KIRKLEES METROPOLITAN COUNCIL INVESTMENT & REGENERATION SERVICE

DELEGATED DECISION TO DETERMINE PLANNING APPLICATIONS

Reference No:	2026/62/90930/E
Site Address:	349, Whitehall Road, Wyke, BD12 9DP
Description:	Demolition of existing garage and erection of single storey side and two storey side and rear extensions
Recommending Officer:	Jennifer Booth

OFFICER REPORT

Existing Ground Floor Plan  
Scale 1:100@A1

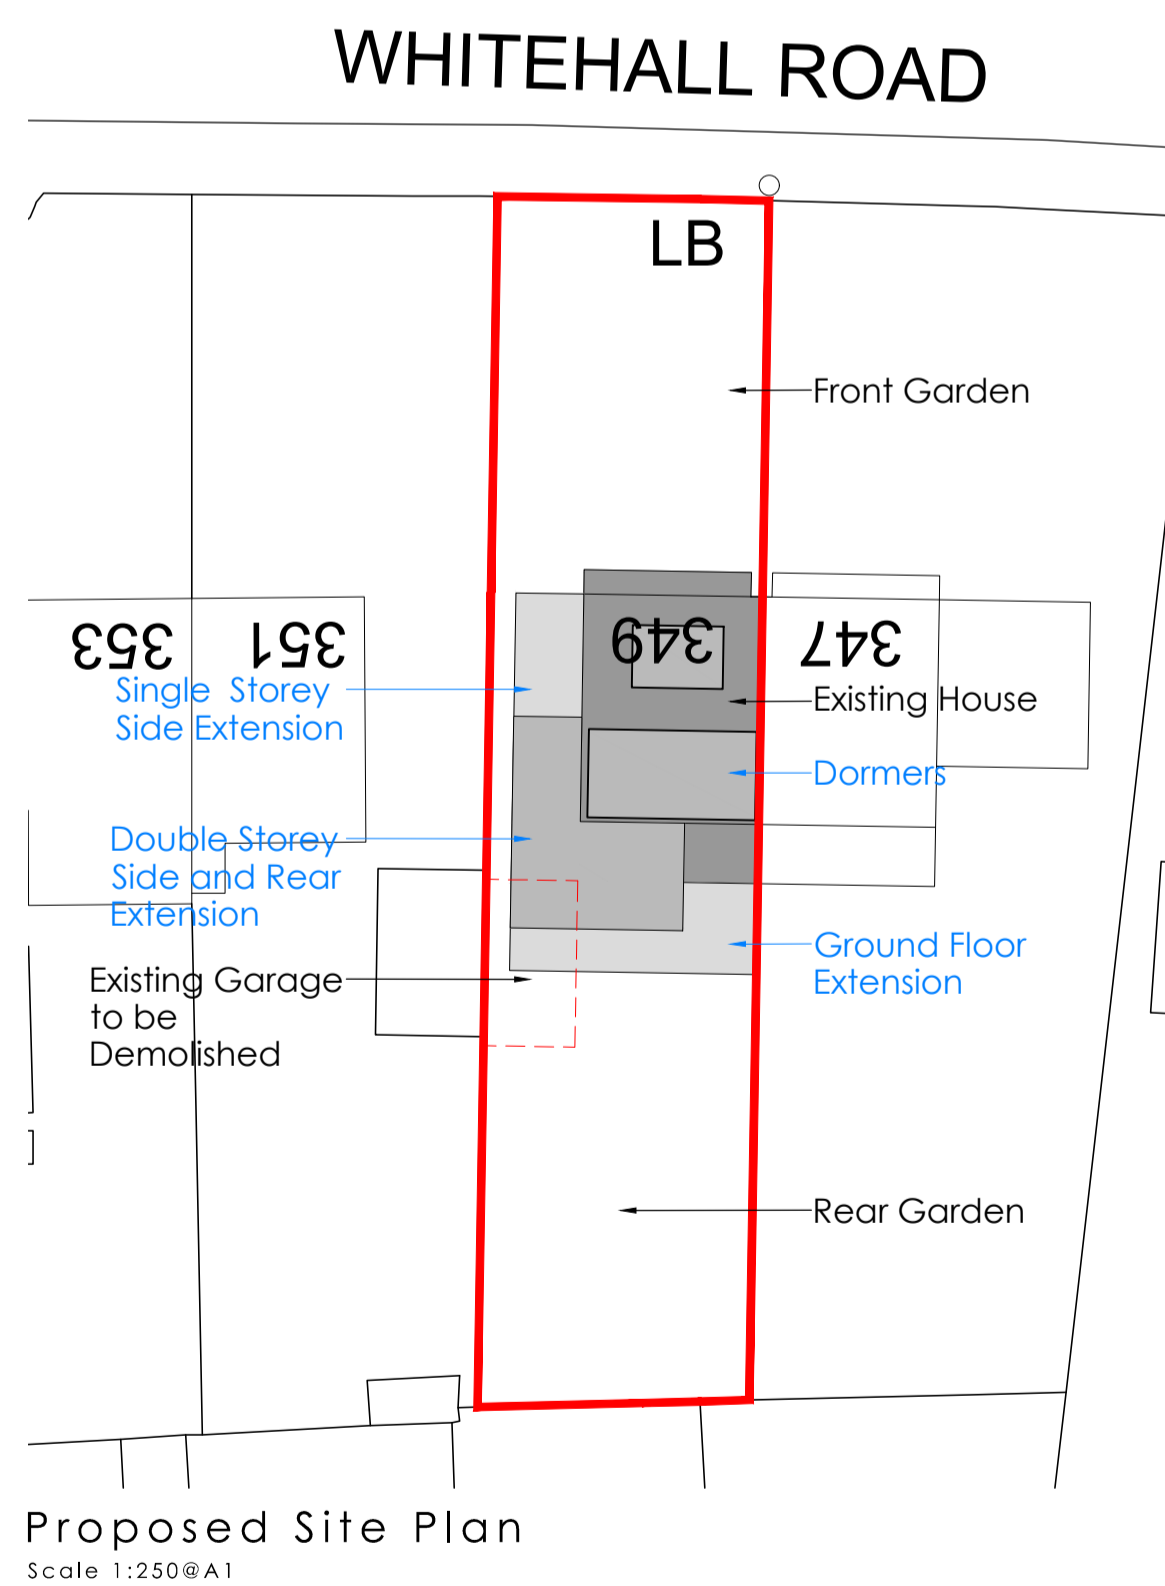
The side extension would project 2.2m from the original size wall, extending the depth of the dwelling on the ground floor. This would be set back 4m at first floor. The rear extension would project 4.9m on the ground floor, extending the width of the dwelling and to the rear of the side extension. The first floor would be inset 2.5m from the shared boundary with a lesser projection of 3.5m. The roof forms would be hipped, lean to and sliding.

Rev - : DD-MM-YYYY : Initial : Issue.
Drawing Number 26-007 - P - 03

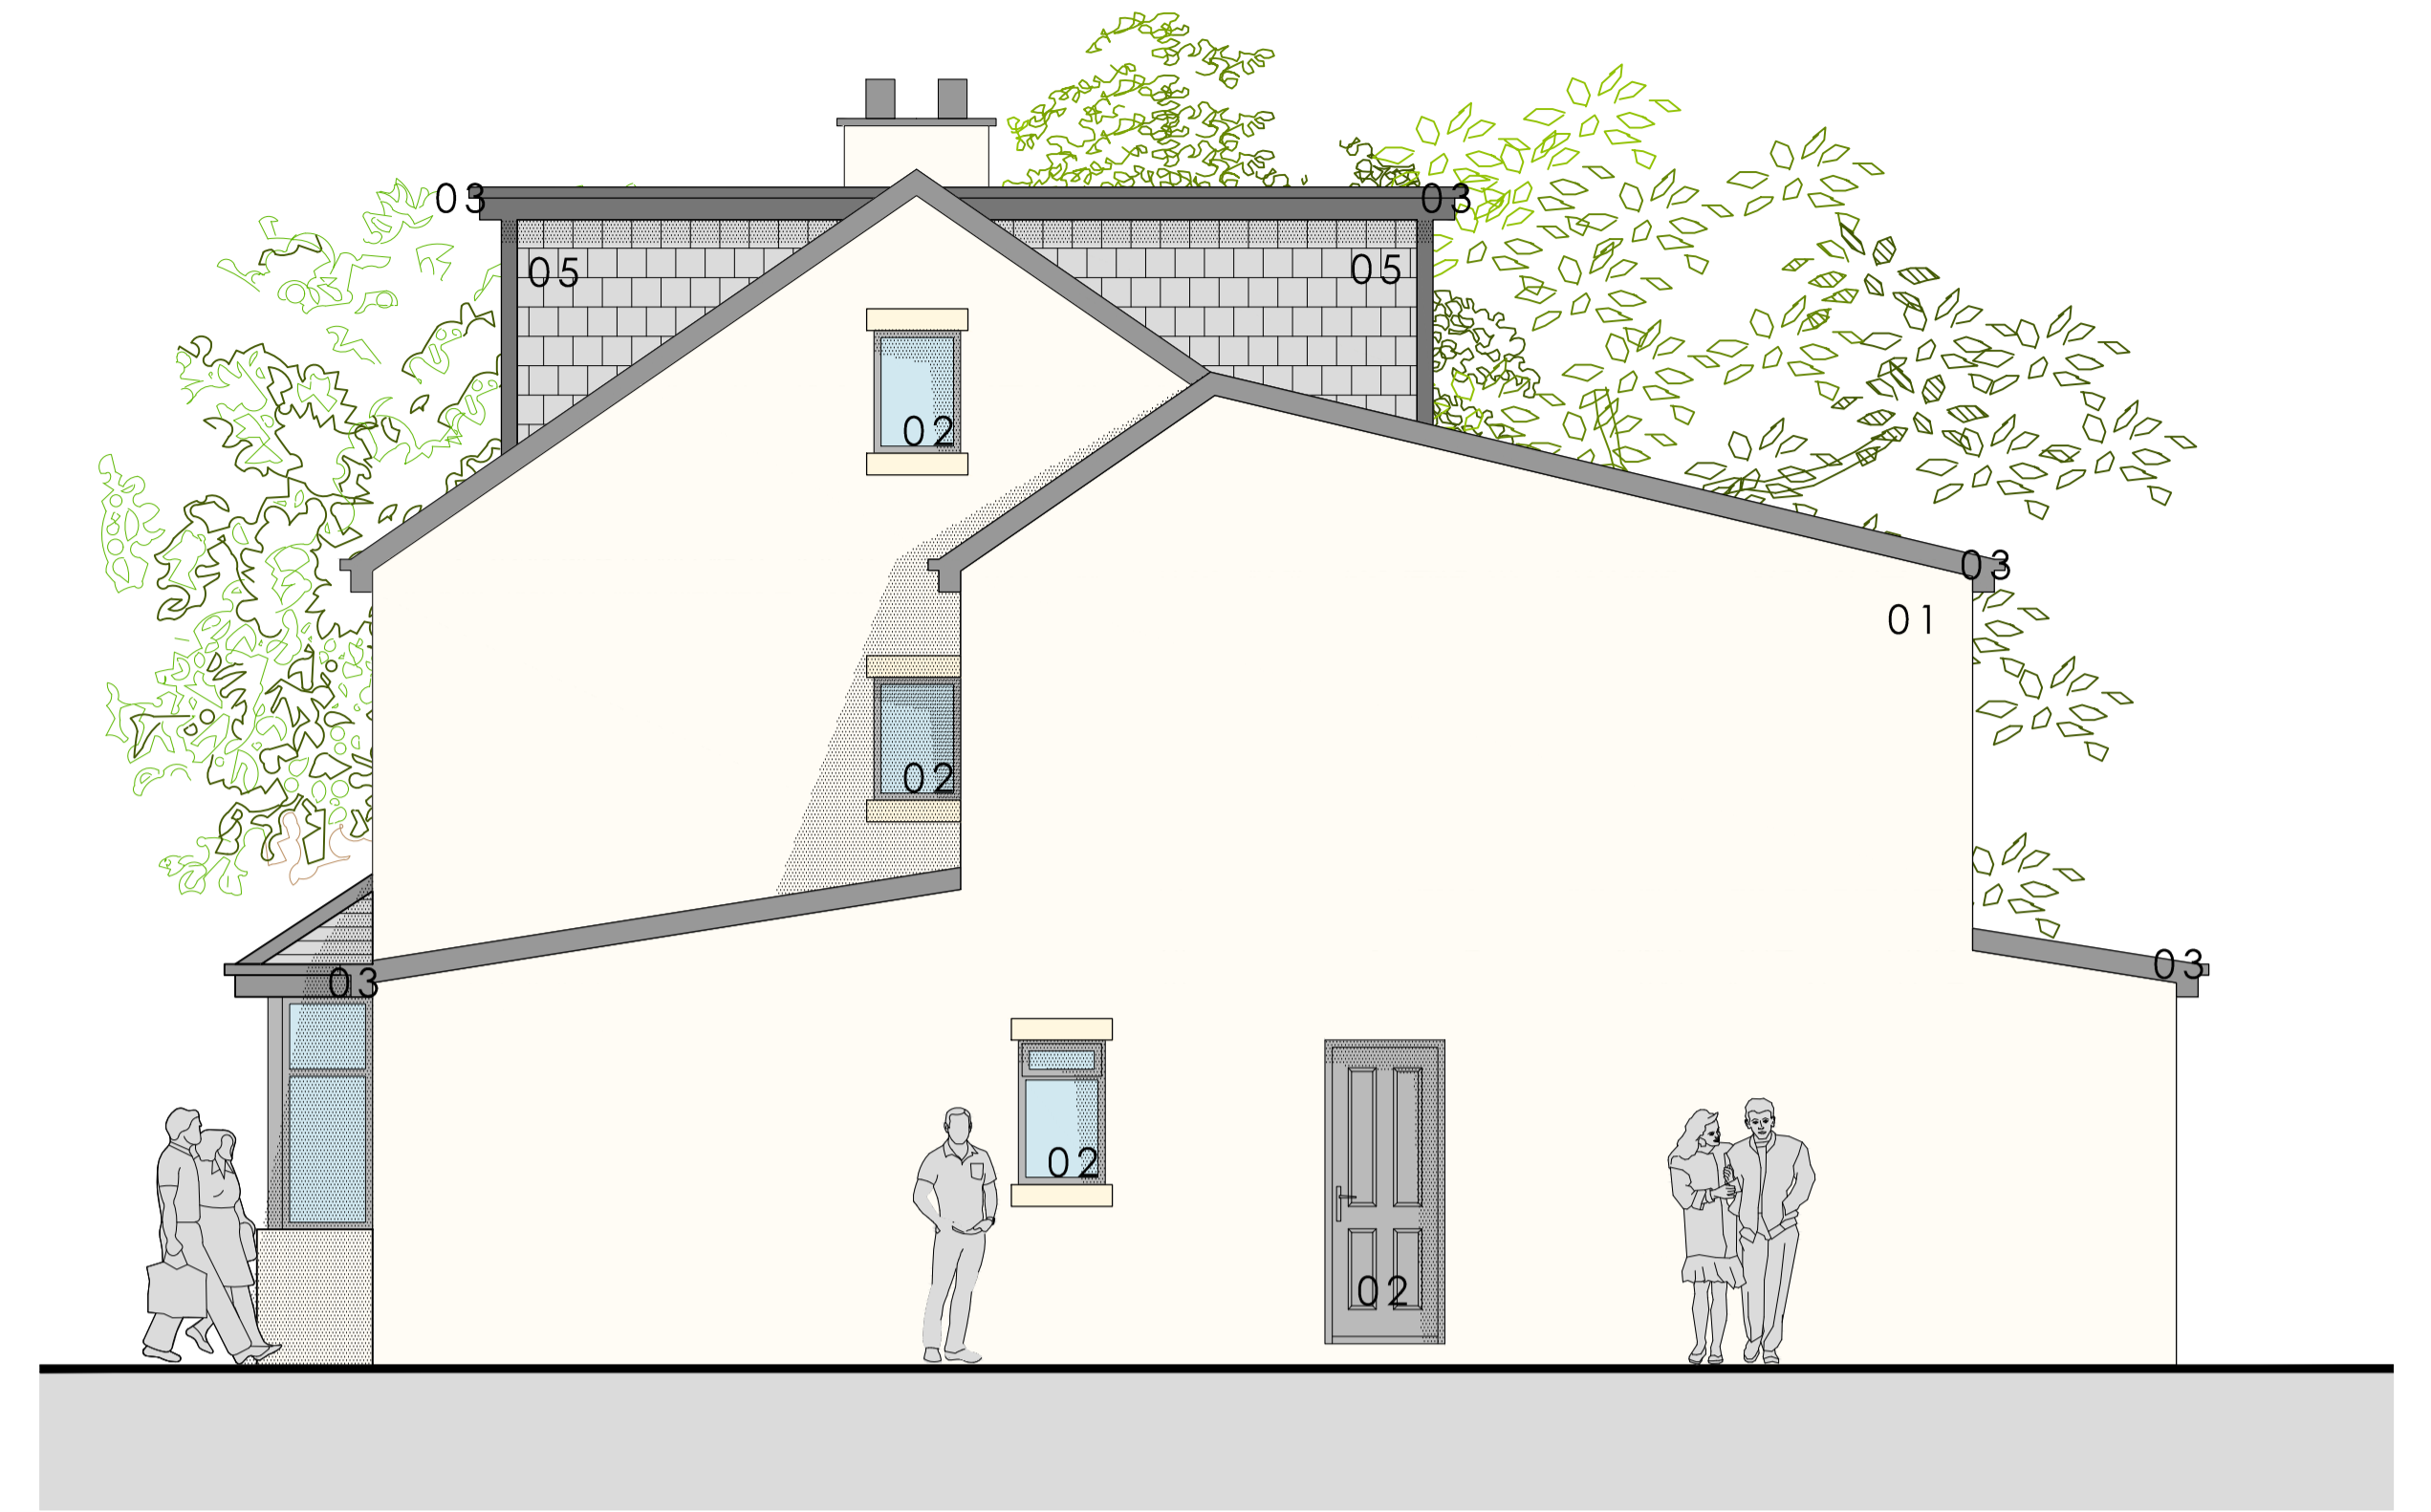
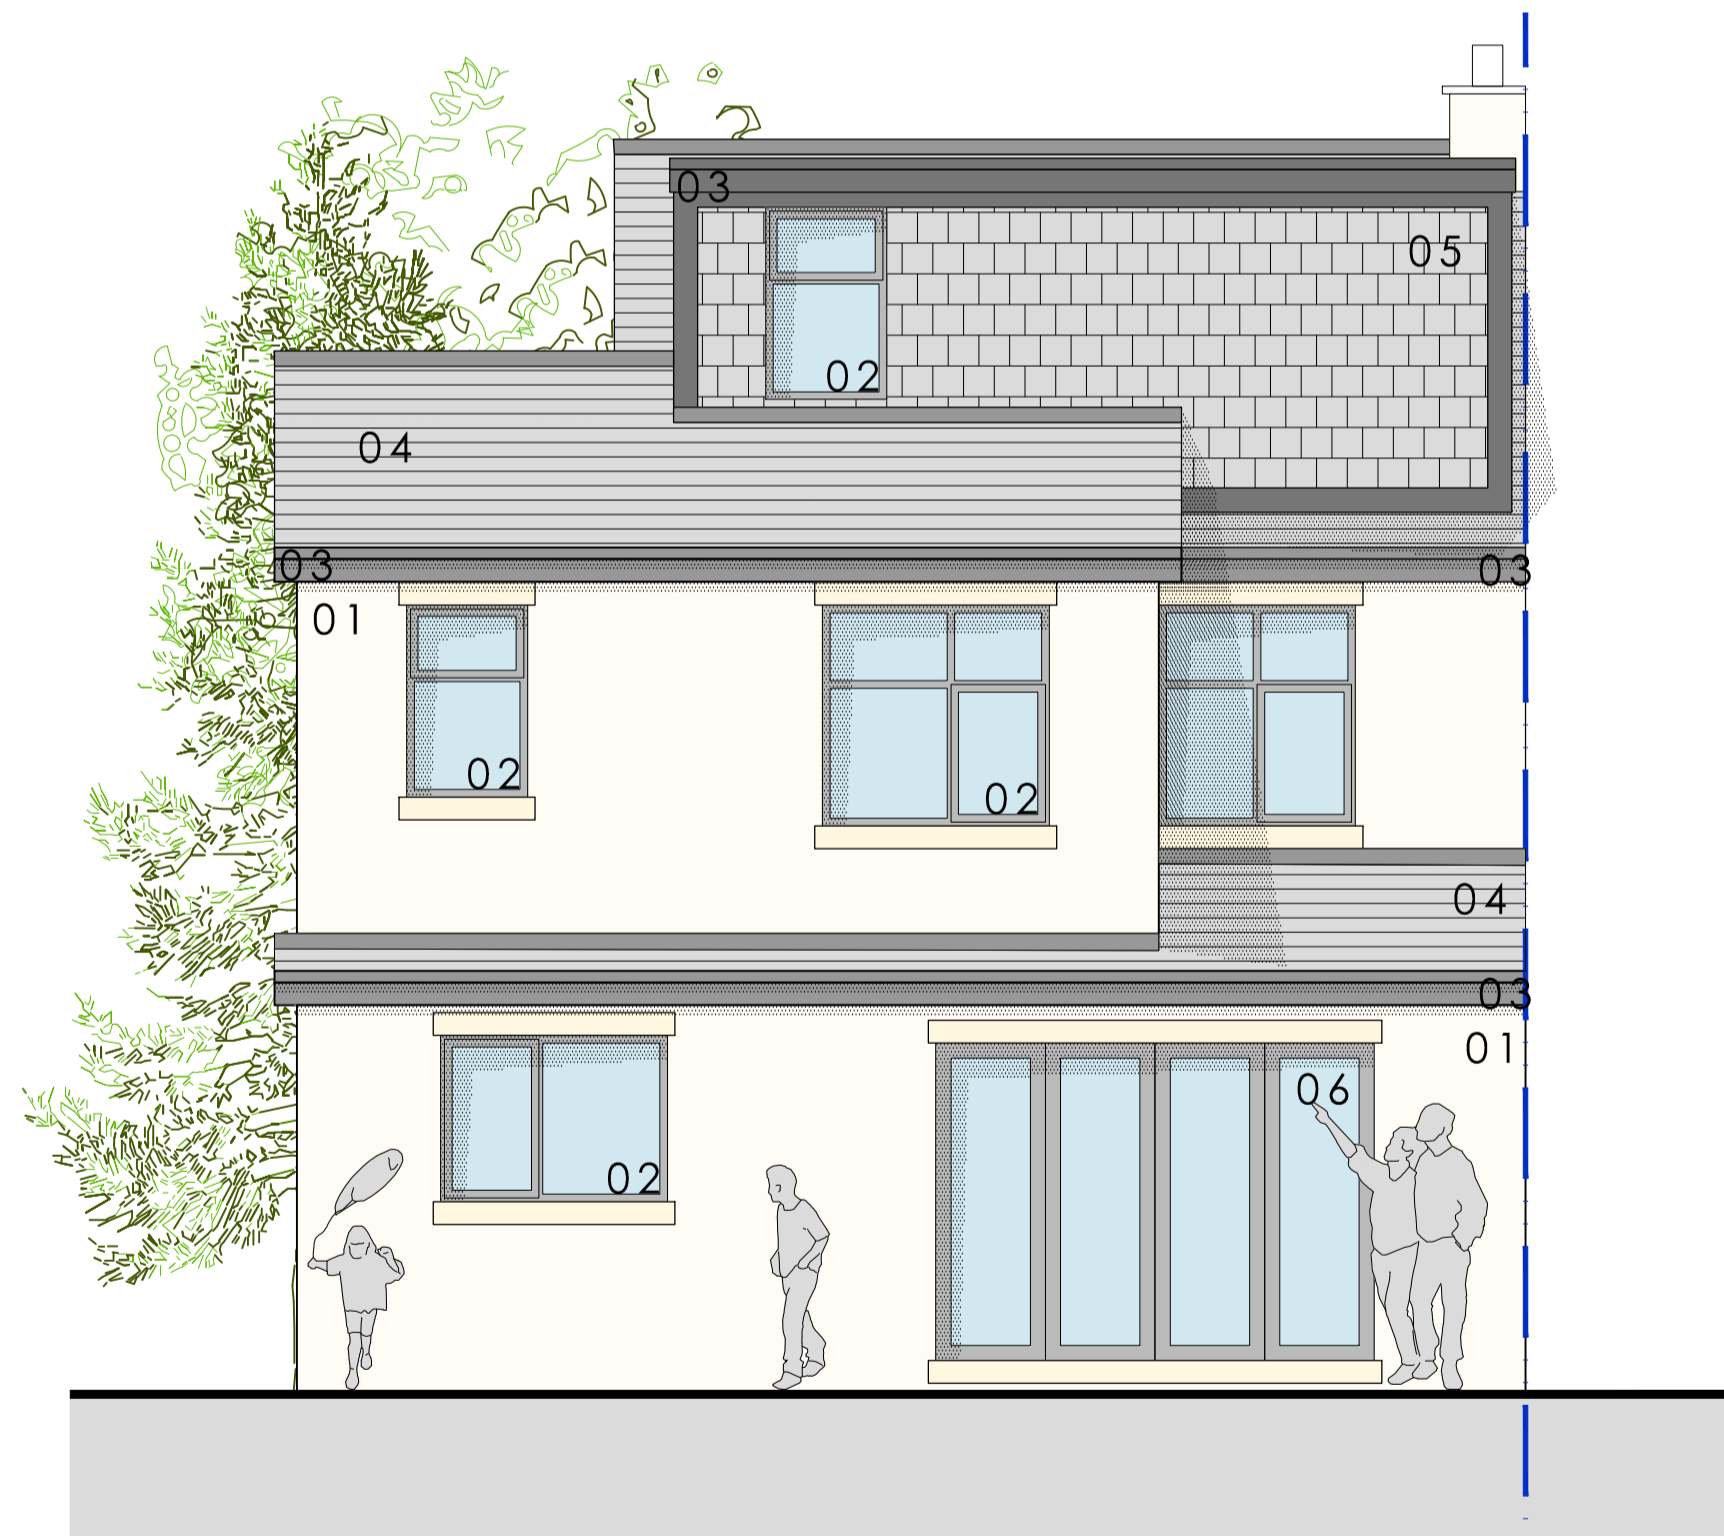
The proposed side extension incorporates a set back and set down from the main dwelling, which assists in achieving a clearly subservient form of development. When considered cumulatively alongside the other elements of the scheme, the overall proposal now appears appropriately subordinate and successfully respects the character and proportions of the host dwelling. In particular, the revised roof form, including the adjusted rear roof plane, results in a balanced and coherent relationship with the main house, integrating well within the overall composition. The proposed use of render and tiles is considered acceptable and, when taken together with the improvements to the scale, form and design, ensures that the development preserves the character and appearance of the host dwelling and makes a positive contribution to the wider streetscene.

The proposed rear extension, comprising both single and two-storey elements, would project approximately 4.9 metres at ground floor level, reducing to 3.5 metres at first floor. While this extends beyond what might typically be supported, the variation in depth between the two storeys helps to break up the massing and results in a form of development that remains proportionate to the host dwelling. The design approach ensures that the extension integrates effectively with the existing property. Furthermore, the roof form contributes positively to the overall composition, adding visual interest and creating a cohesive and balanced appearance. The use of materials is considered appropriate and, when combined with the scale, form and design of the proposal, ensures that the extension reads as a well-considered and subservient addition that preserves the character and appearance of the main house.

The ground floor of the rear extension would be constructed up to the shared boundary with an increased projection over the existing single storey. It is noted that the neighbour also has their own single storey rear extension and the increased potential for overshadowing and overbearing is limited. The first floor would be set away from the shared boundary limiting the potential for overshadowing or overbearing. The windows proposed would look into the applicants own amenity space.

The side extension would reduce the space between the properties and the rear element would extend beyond the level of the main house. However, a gap would be retained which would reduce overshadowing and overbearing. The windows proposed would look into the applicants own amenity space.

- Out of character due to scale – **Response:** *amended plans have been received which reduce the overall scheme and retains the hipped roof style of the property.*
